STATE OF NORTH CAROLINA
DEPARTMENT OF TRANSPORTATION

Subject: **Application for Modification to Section 404 Nationwide Permit 33** for the proposed replacement of Bridge No. 416 over Beaverdam Creek on SR 2550 in Davidson County, Federal Aid Project No. BRSTP-2550(1), State Project No. 8.2604601, WBS Element: 33459.1.1.1, Division 9, TIP B-4103.

Enclosed are revised permit drawing Sheets 5, 6, 7, and 9A of 9 and revised Preconstruction Notification Form. The permit drawings were revised to show the addition of a temporary work bridge. Total temporary impacts for the project are <0.03 acres.

PROJECT REFERENCE NO. B 4103 SHEET NO. 2-B
 RW SHEET NO.
 ROADWAY DESIGN ENGINEER
 HYDRAULICS ENGINEER
Permit Drawing
Sheet 6 of 9
PRELIMINARY PLANS
 DO NOT USE FOR CONSTRUCTION
 rev. 11/27/07

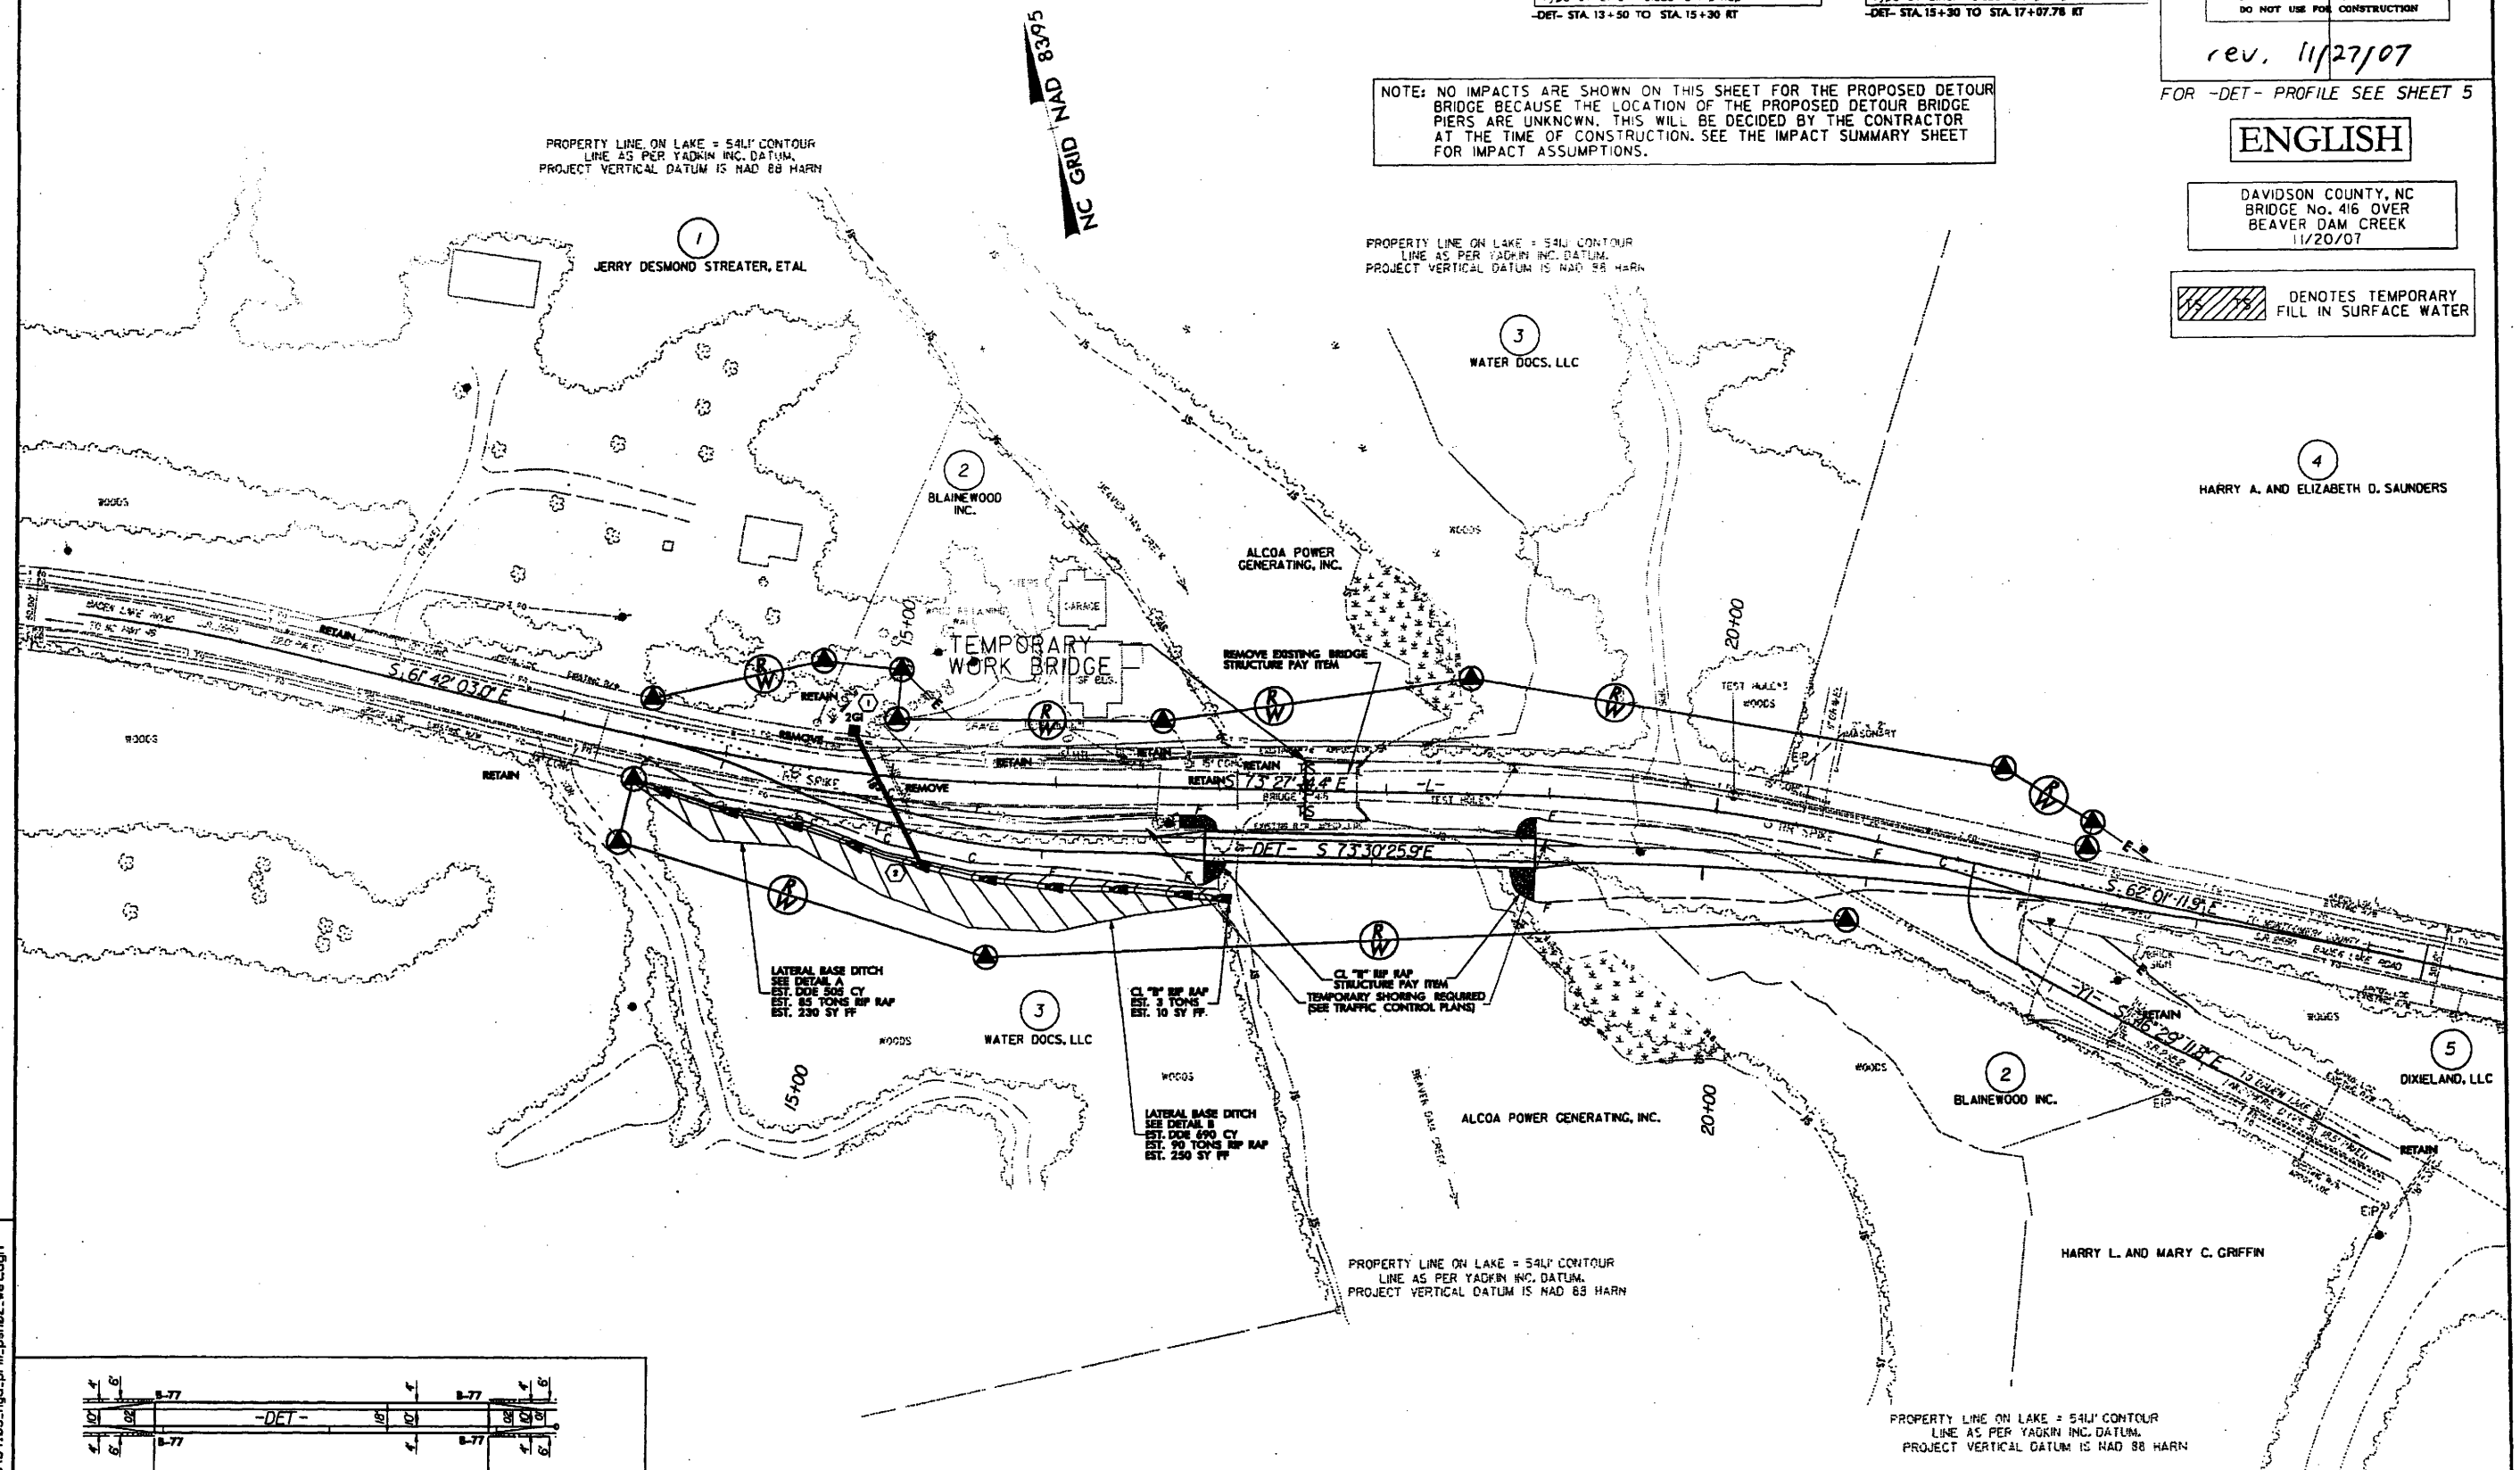
The purpose of this submittal is to request a modification to the Section 404 Nationwide 33 Permit. The modification for the permit is for the use of a temporary work bridge. The temporary work bridge will be used to install the interior bent for the new bridge. The temporary work bridge will have one bent in the water that will be one foot wide. The width of the temporary work bridge will be 35-feet. The use of the temporary work bridge will result in <0.01 acres of temporary stream impacts. No other jurisdictional impacts will occur due to this change.
